10 July 2015

**NOTIFICATION OF MODIFICATION APPLICATION FOR NEW SPACE PROJECT -
UNIVERSITY OF NEWCASTLE (SSD 6457 MOD 1)**

CLIENT

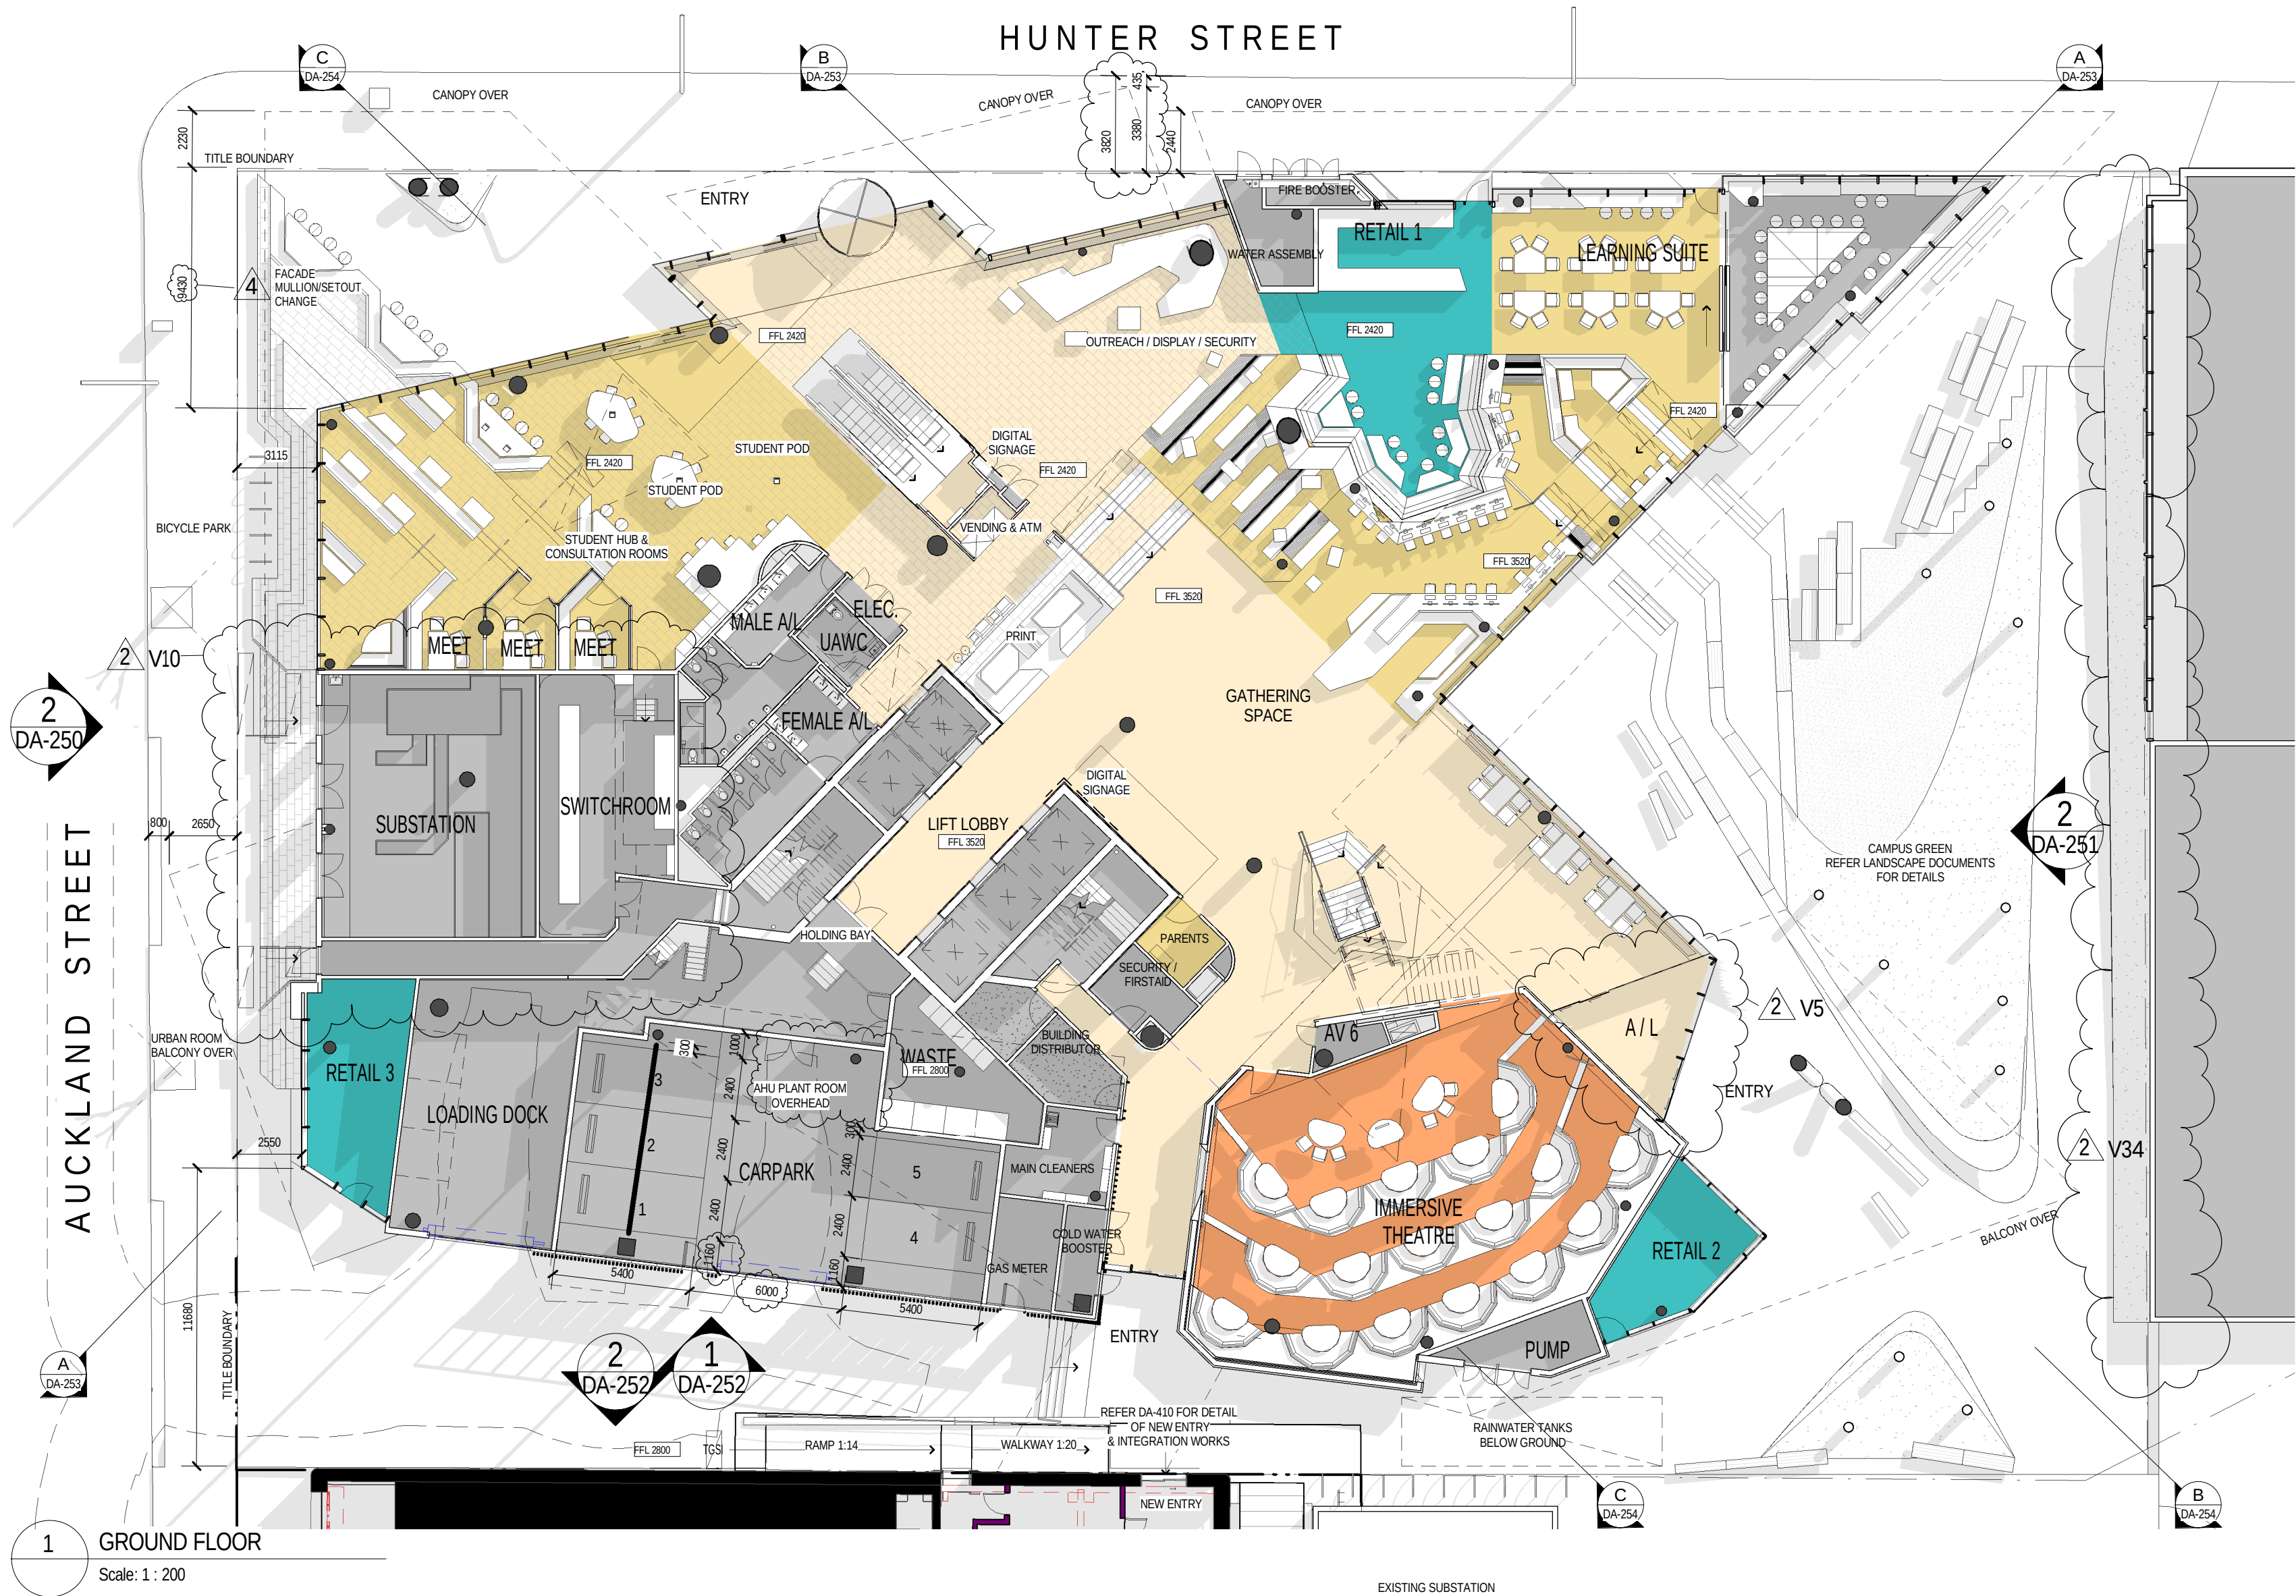
- There is no description in the JBA letter dated 11 June, 2015 to the modifications V9, V14, V20 and V32 indicated on the amended plans. Similarly, there is no explanation for the inclusion of modification 'clouds' around the building setbacks distances indicated on drawing DA-200.

- The notation '*Urban Room Balcony Over*' on the ground floor drawing is misleading and should be removed. The Urban Room on level 1 is an enclosed space which forms part of the gross floor space of the building.

It is recommended the applicant be required to highlight the proposed modifications onto the relevant approved design plans or alternatively submit amended design plans so that the proposed changes to the design of the building are clearly distinguishable.

DRAWING No.
DA-000

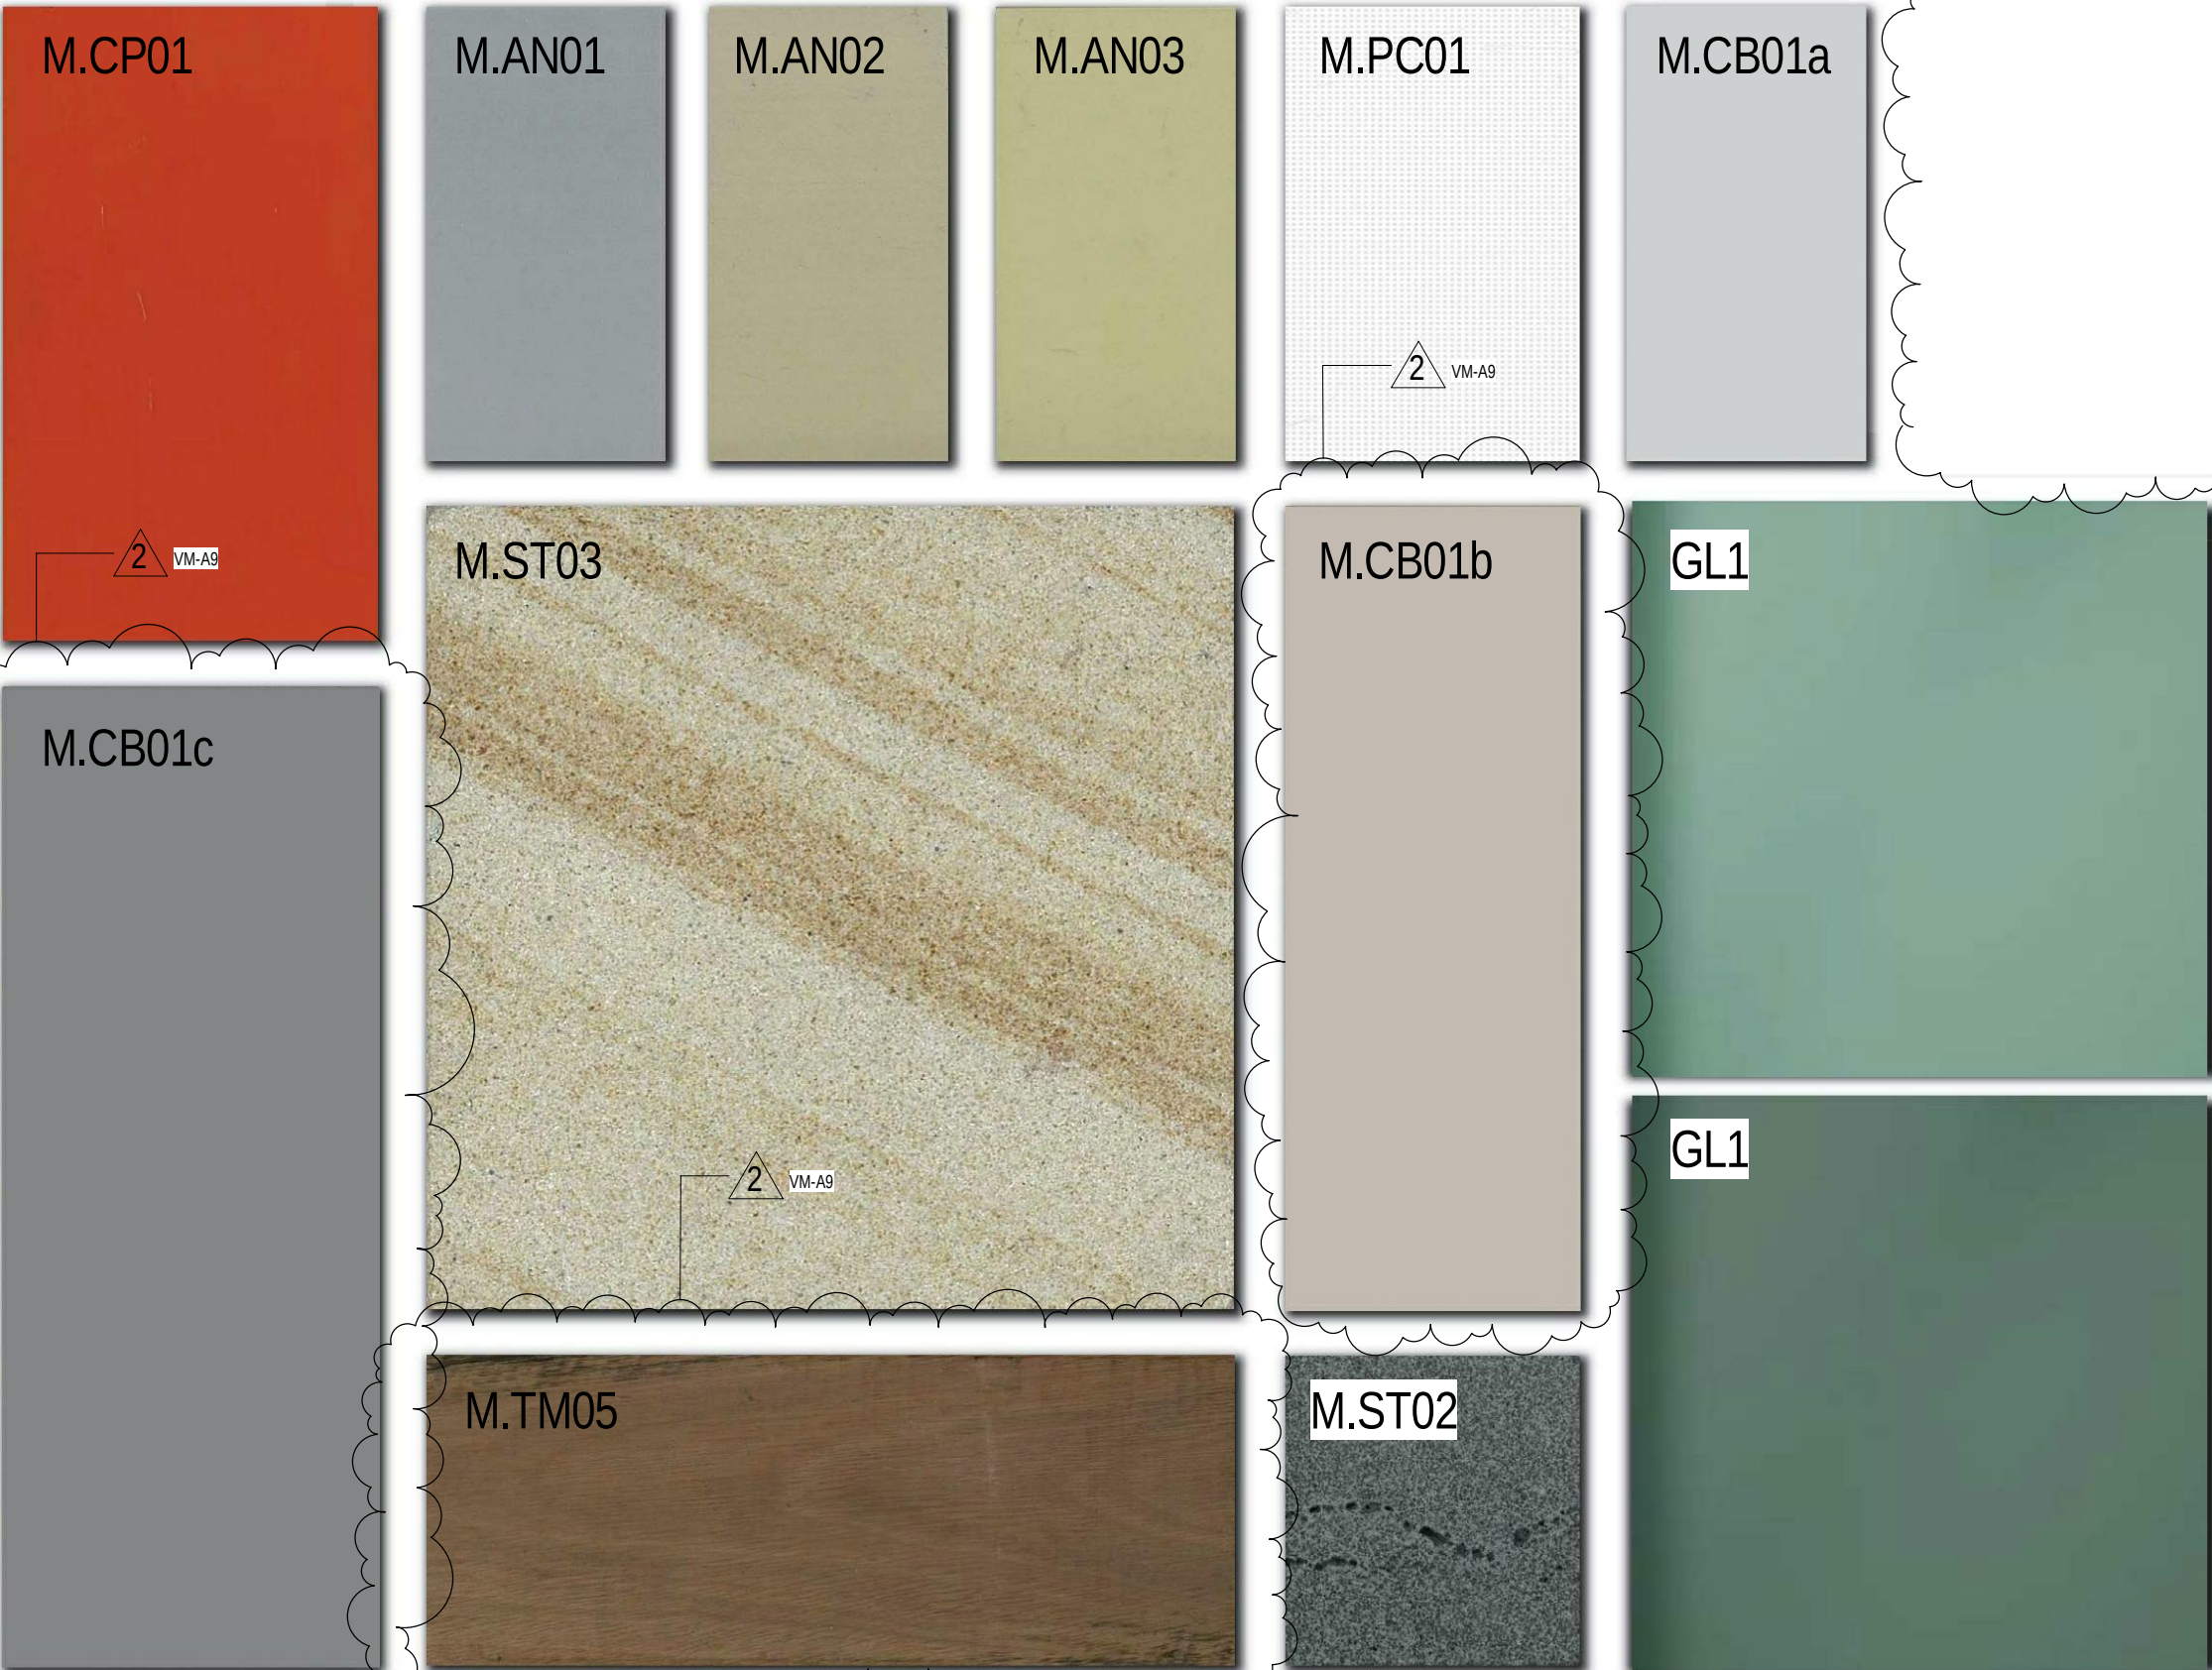
- It is noted that the 'green wall' to the Christie Place substation, proposed to be removed, is still included in the artist's impression on the 3D Visualisation & Materials Board drawing DA-000.
